From: [Simon Halcrow](#)
To: [Michelle Niles](#)
Cc: [David O'Connell](#)
Subject: RE: Notice of Modification Request - Casuarina Town Centre Project Approval (MP 06_0258 MOD 12)
Date: Friday, 8 February 2019 3:42:11 PM
Attachments: [image001.png](#)
[image002.png](#)
[image003.jpg](#)
[image004.jpg](#)
[image005.jpg](#)
[image006.png](#)
[image007.jpg](#)
[image008.jpg](#)
[20190125 - J150 - Engineering Assessment V3.pdf](#)

From: Michelle Niles [mailto:Michelle.Niles@planning.nsw.gov.au]
Sent: Friday, 21 December 2018 3:48 PM
To: Simon Halcrow <simon@planitconsulting.com.au>
Subject: Fwd: Notice of Modification Request - Casuarina Town Centre Project Approval (MP 06_0258 MOD 12)

The proposal seeks approval to subdivide SP 94481 into two separate allotments, to correct an error in the Survey undertaken during works associated with MOD 6 which incorrectly amalgamated a car parking lot and medium density housing lot.

Figure 3 | Alternative Sewer Connection Locations

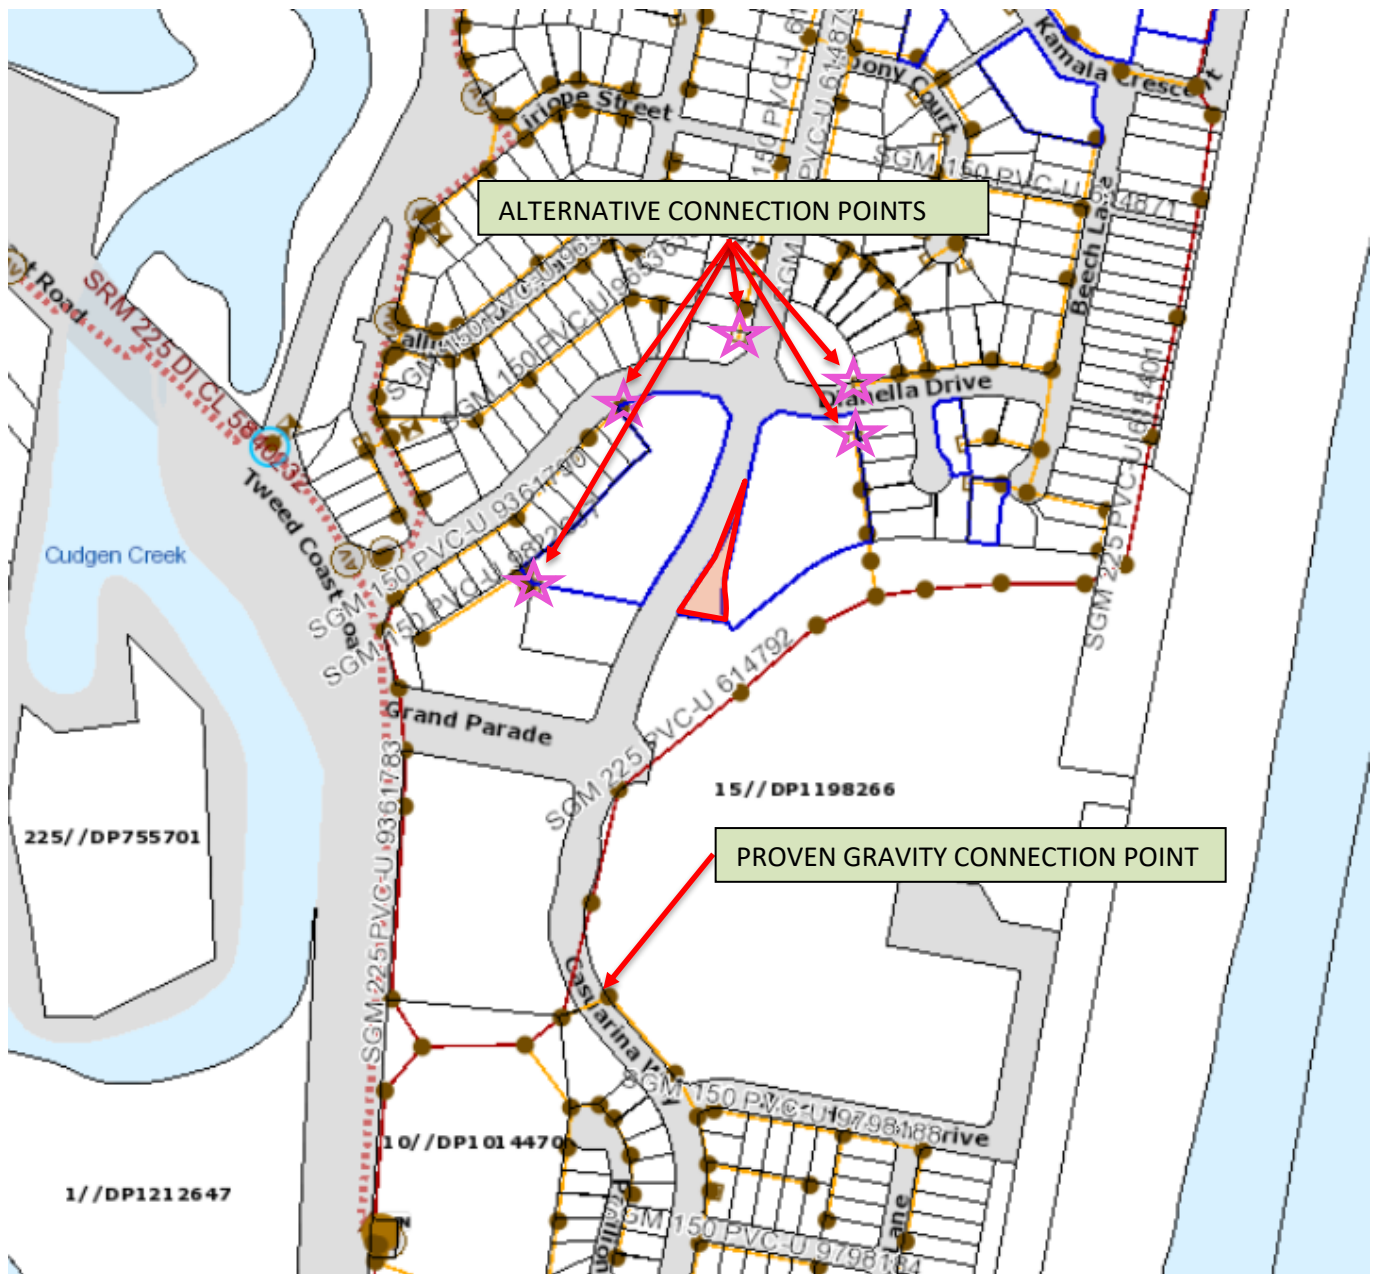
- 1) In order for proposed lot 1 to be serviced by sewer the proposal seeks to extend through private property. It is most likely that an easement will be required over future Lot 51 to service proposed Lot 1. Hence, the proposal is relying on extending a sewer line within private property (creation of an easement). No owners consent has been provided for sewer in private property.
- 2) The application does not demonstrate how the car parking lot can be adequately serviced by sewer....demonstrate connection point and gradients.

The applicant has updated the information and recommended that the lot connect to the sewer proposed to the south of the lot, however has made no effort to confirm how the works would be undertaken or how owners consent for easements across private property would be obtained.

The proposed two lot subdivision is not supported as the applicant has not demonstrated that the lot can be adequately serviced for sewerage. It is recommended that the application be withdrawn, or further information provided to demonstrate how the services can be provided as part of the currently proposed civil construction works proposed for Casuarina Town Centre.

Please find attached an updated engineering report that addresses council's concerns.
I would like to agree on some wording for the most suitable connection point to be used for retic sewer supply to the site, as there are a number of options available, and costs to establish can vary.
Please see the attached and advise of progression from here and per my request herein.

| DRAWING TITLE:<br>SERVICES CONNECTIONS |                      |                         |                      |           |

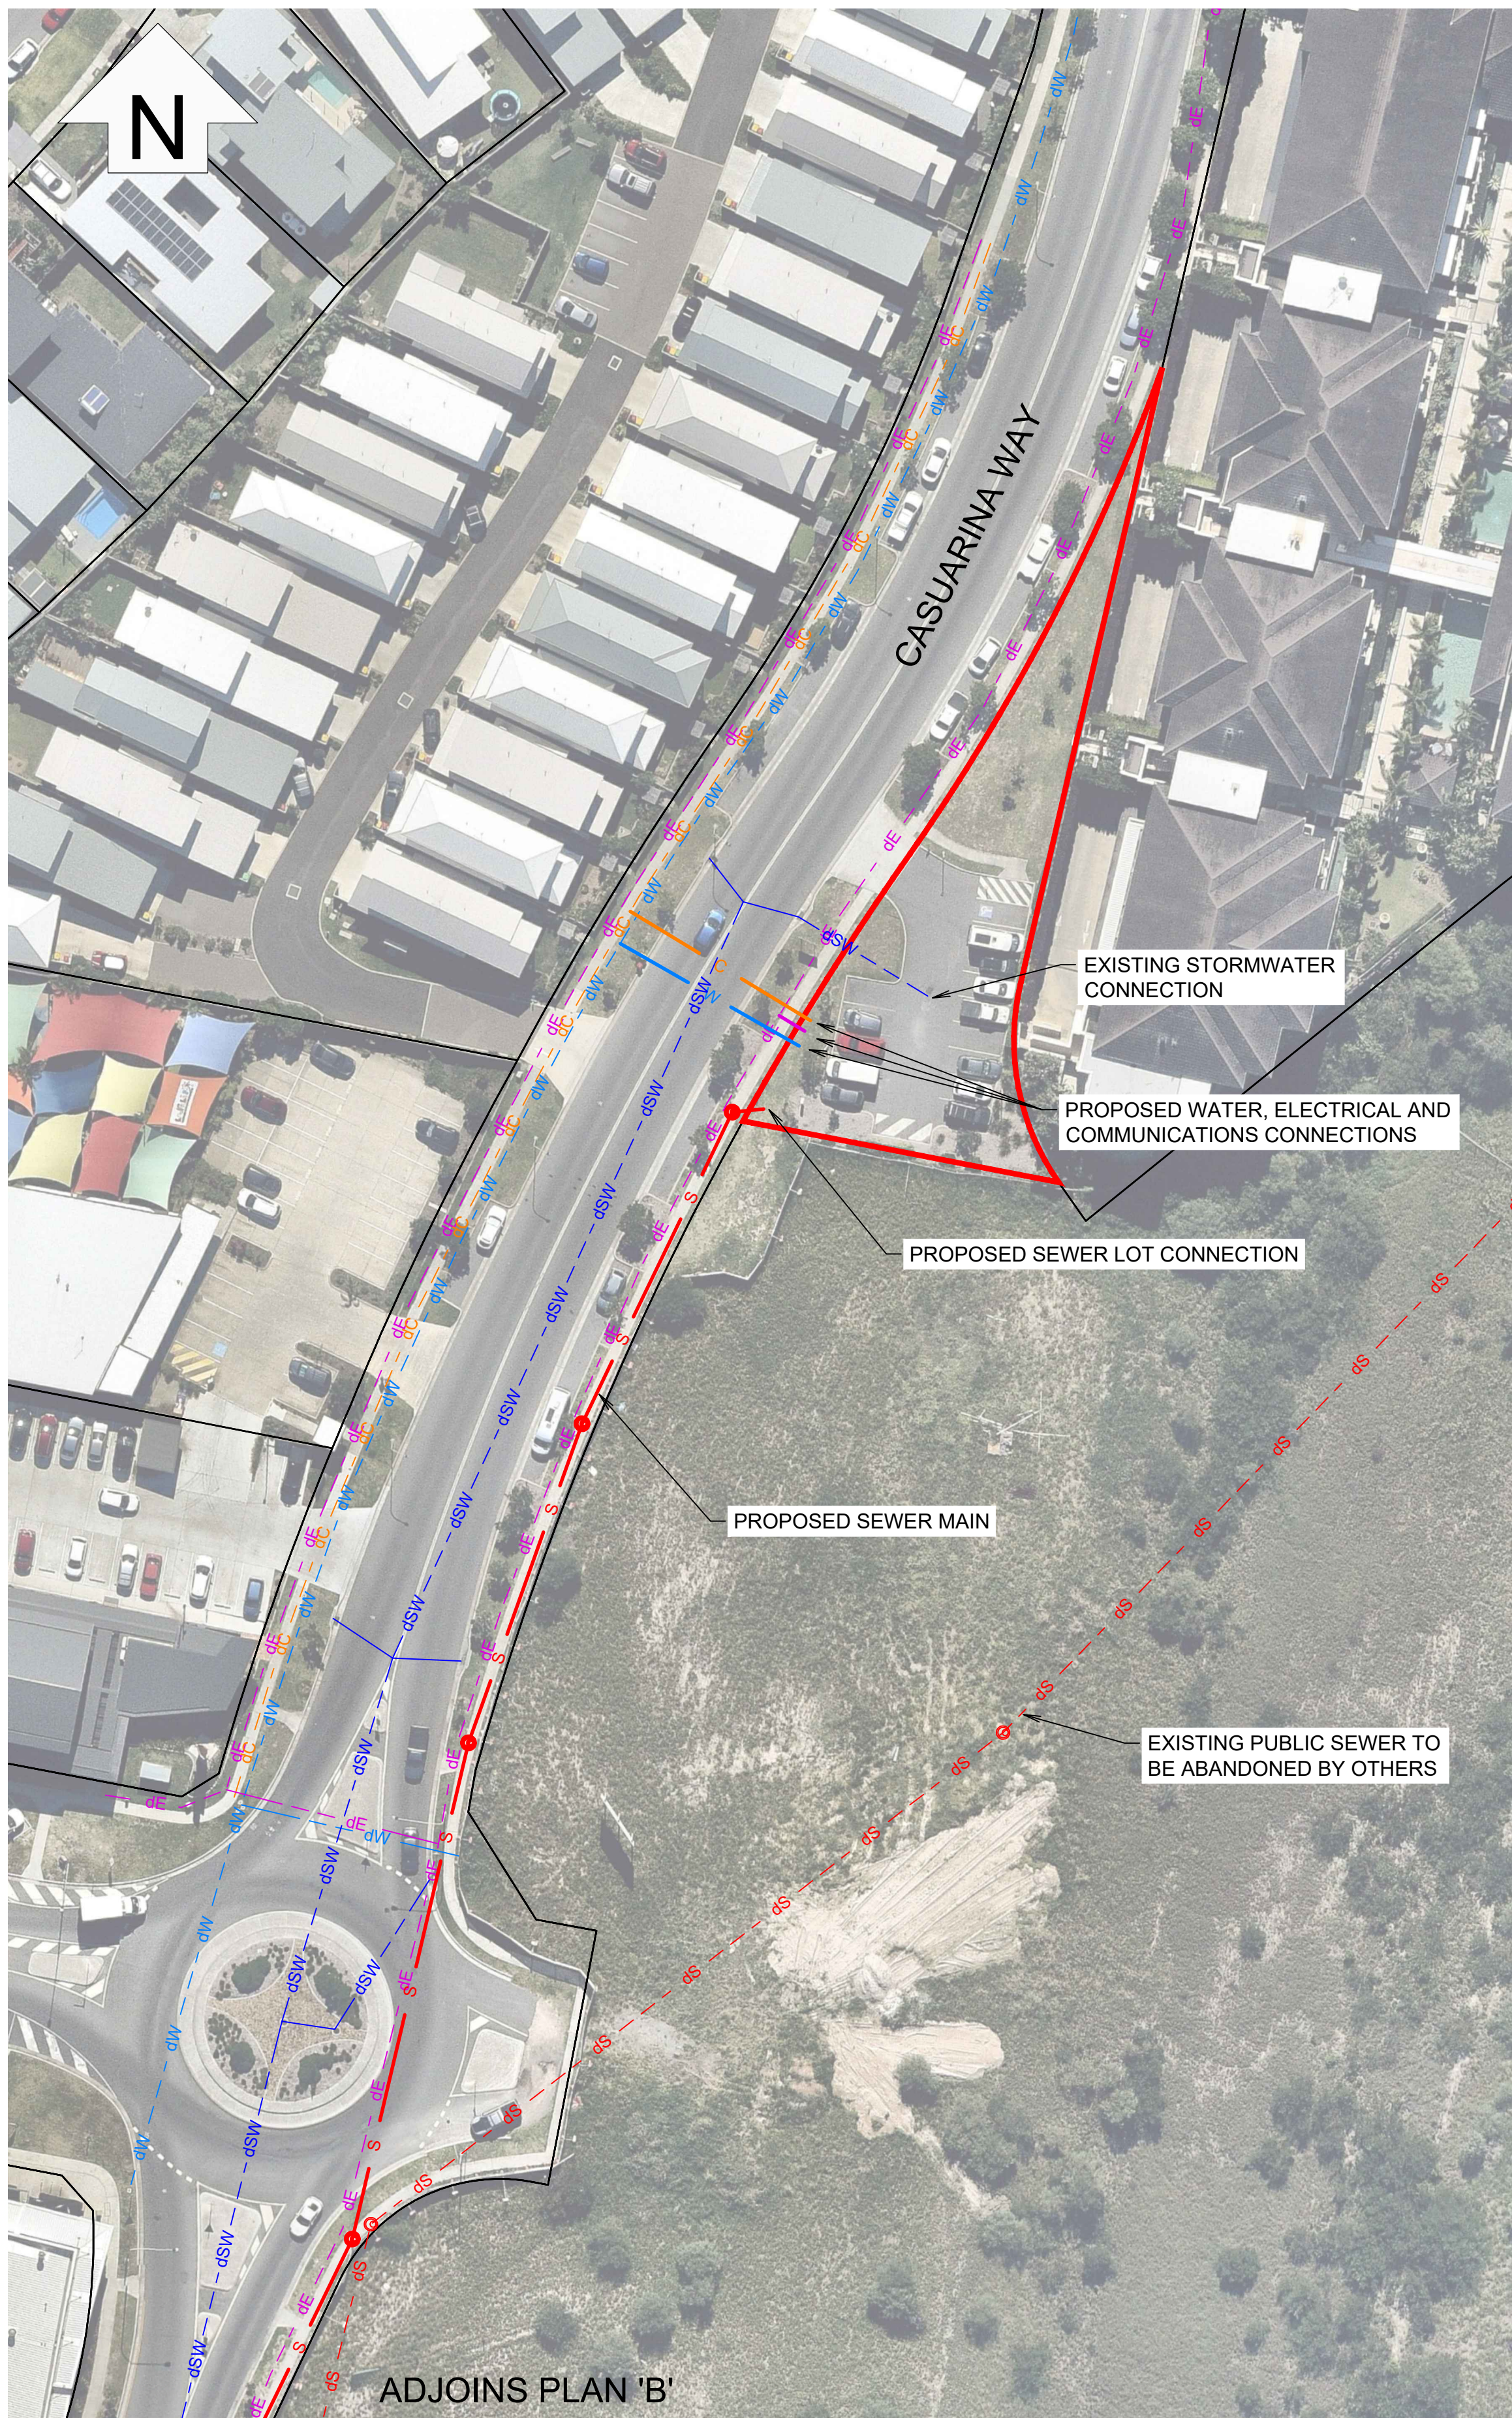
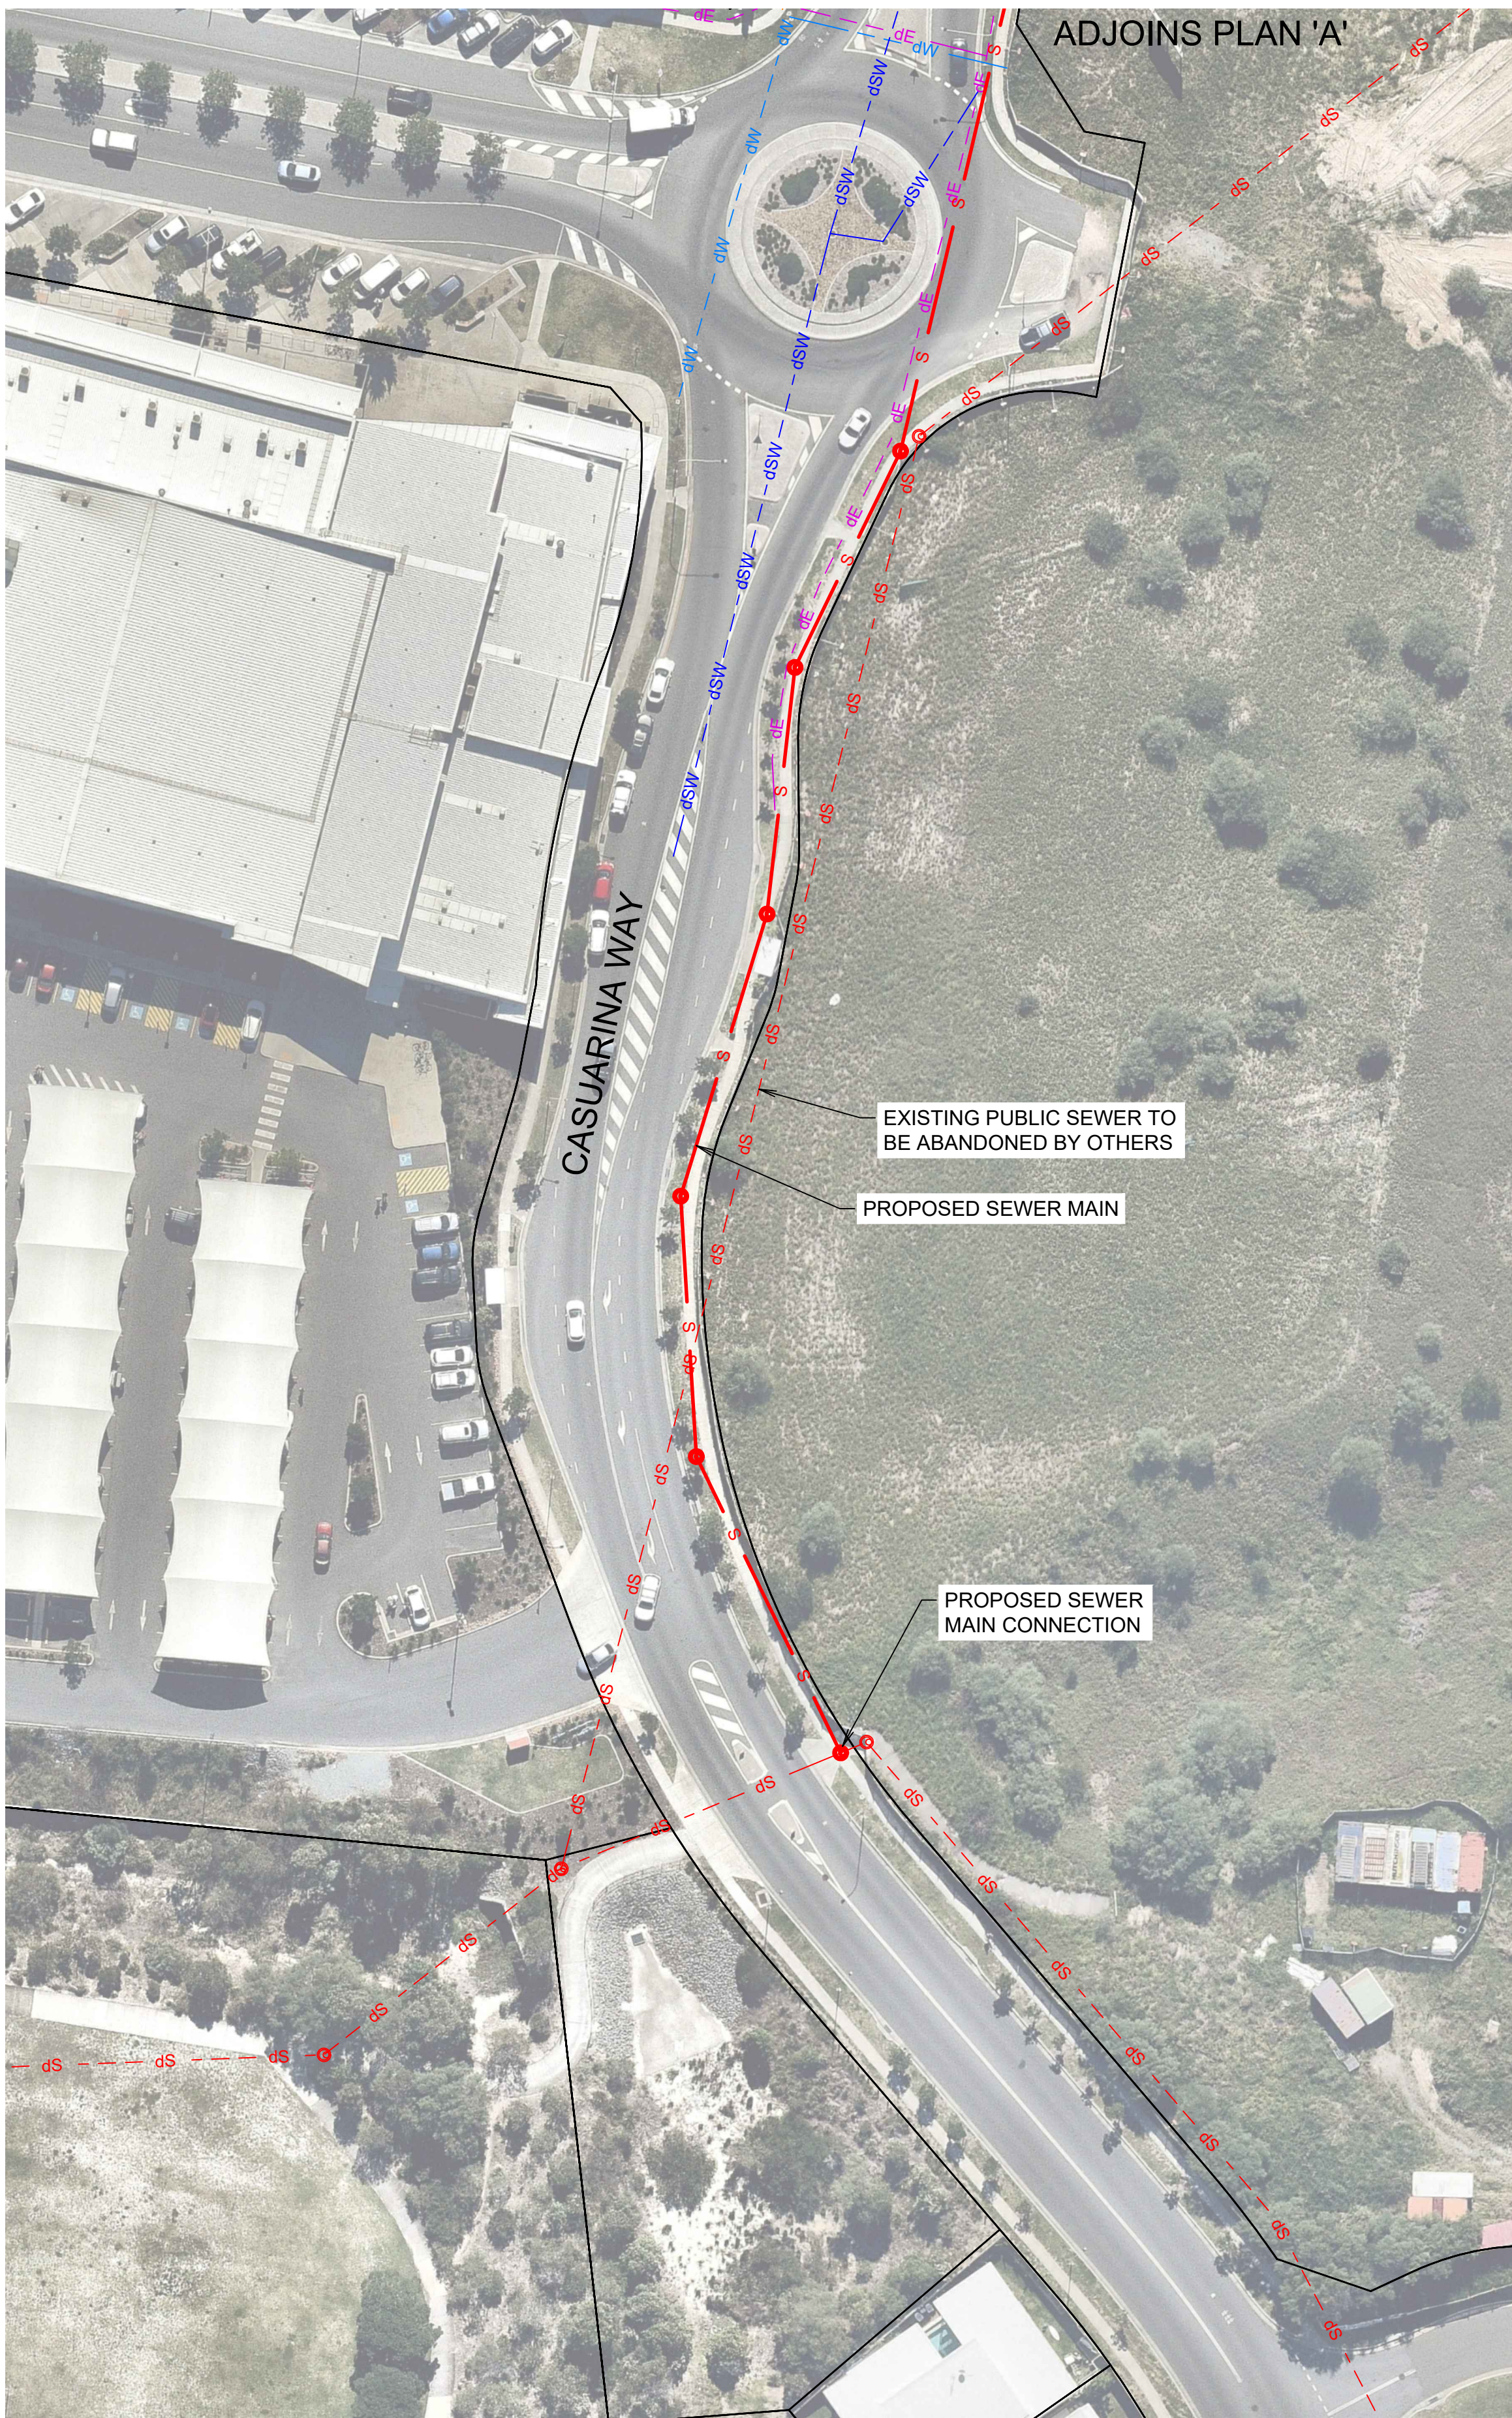
Please note preference is for proposed Lot 1 be serviced as part of the two lot subdivision. If not serviced then appropriate easements be obtained for services over private property and demonstration how it would be serviced.

Given the possibility of dwelling construction it is recommended that the developer demonstrate how the site will be connected with sewer to the proposed car parking parcel being Lot 1.
